D-49 Transportation Center  
Traffic Impact Study  
(LSC #S214340)  
October 12, 2021

# **D-49 Transportation Center**

## **Traffic Impact Study**

Please add PCD File  
No. U-221

Proposed Site and Access Plan

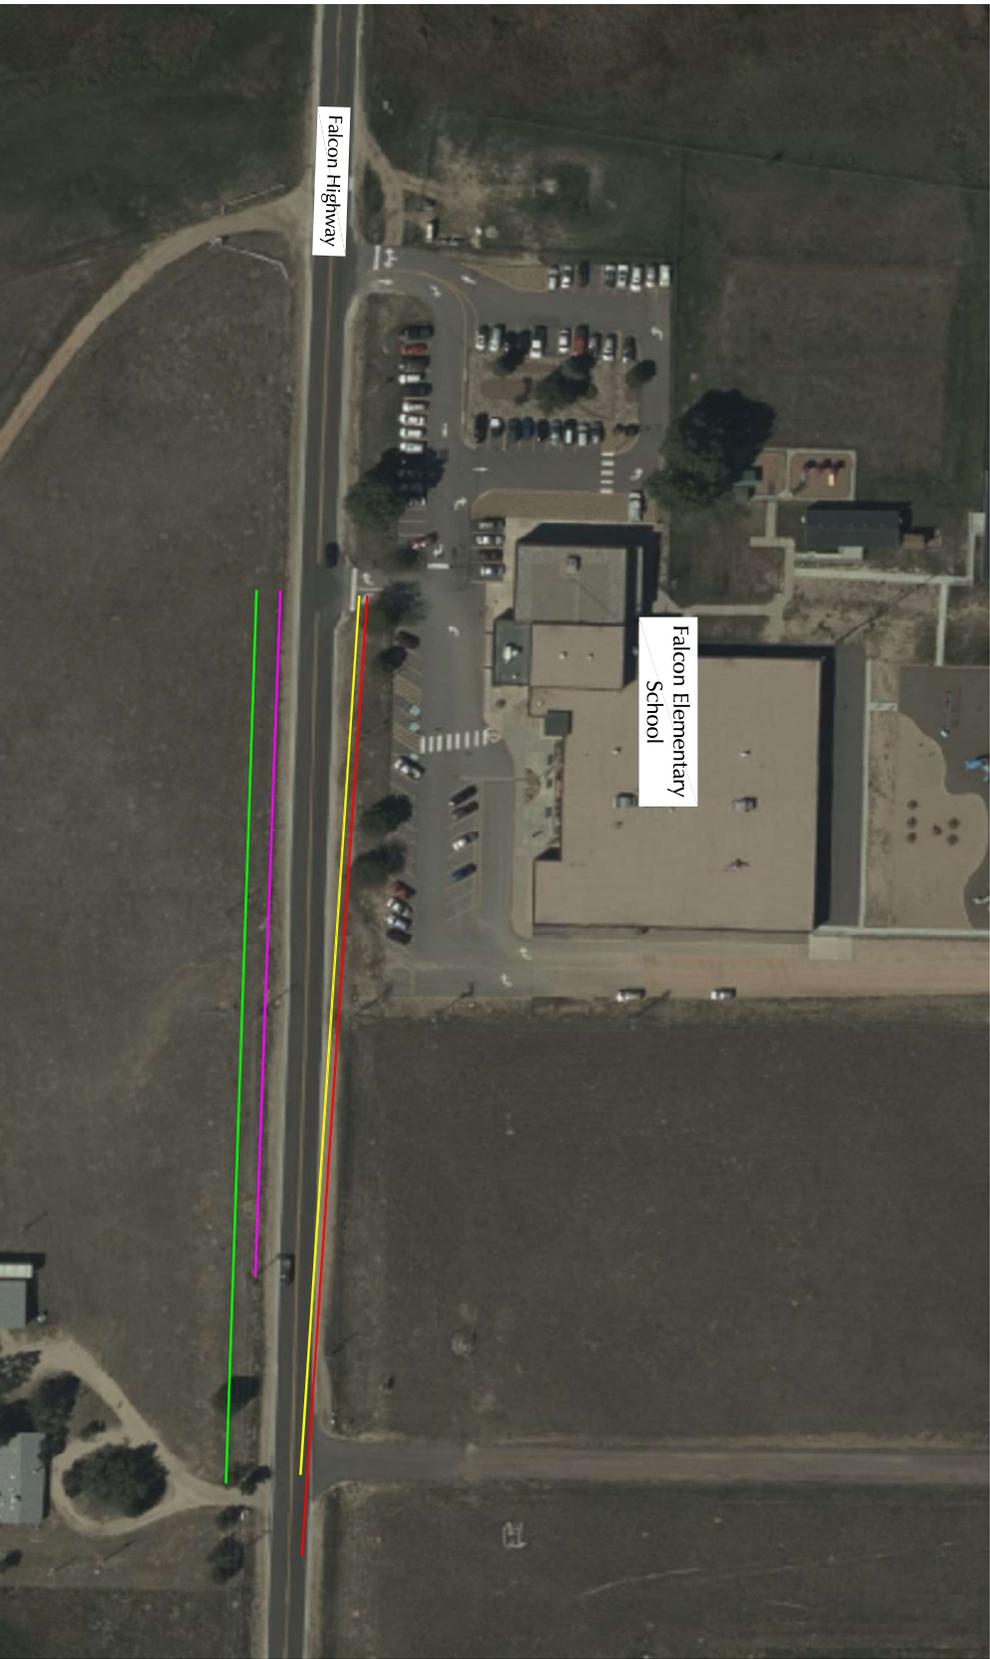
Will all outbound traffic use the Falcon Hwy access?

Please provide an exhibit with sight distance lines for both design vehicles.

Figure 6

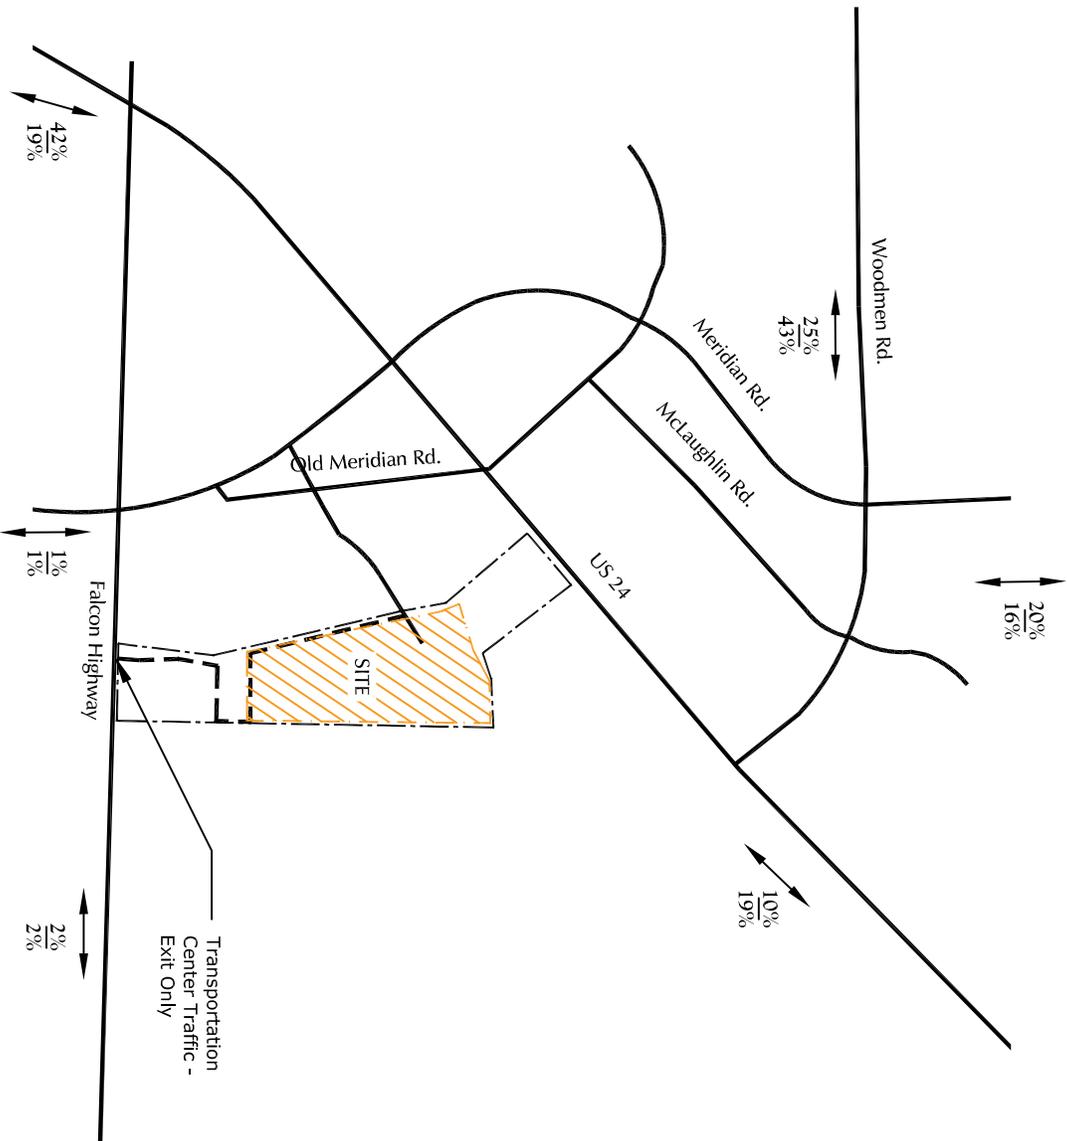
Please explain what guarantees the directional distribution will remain the same if Gelbvien Road can provide both ingress and egress to the site?
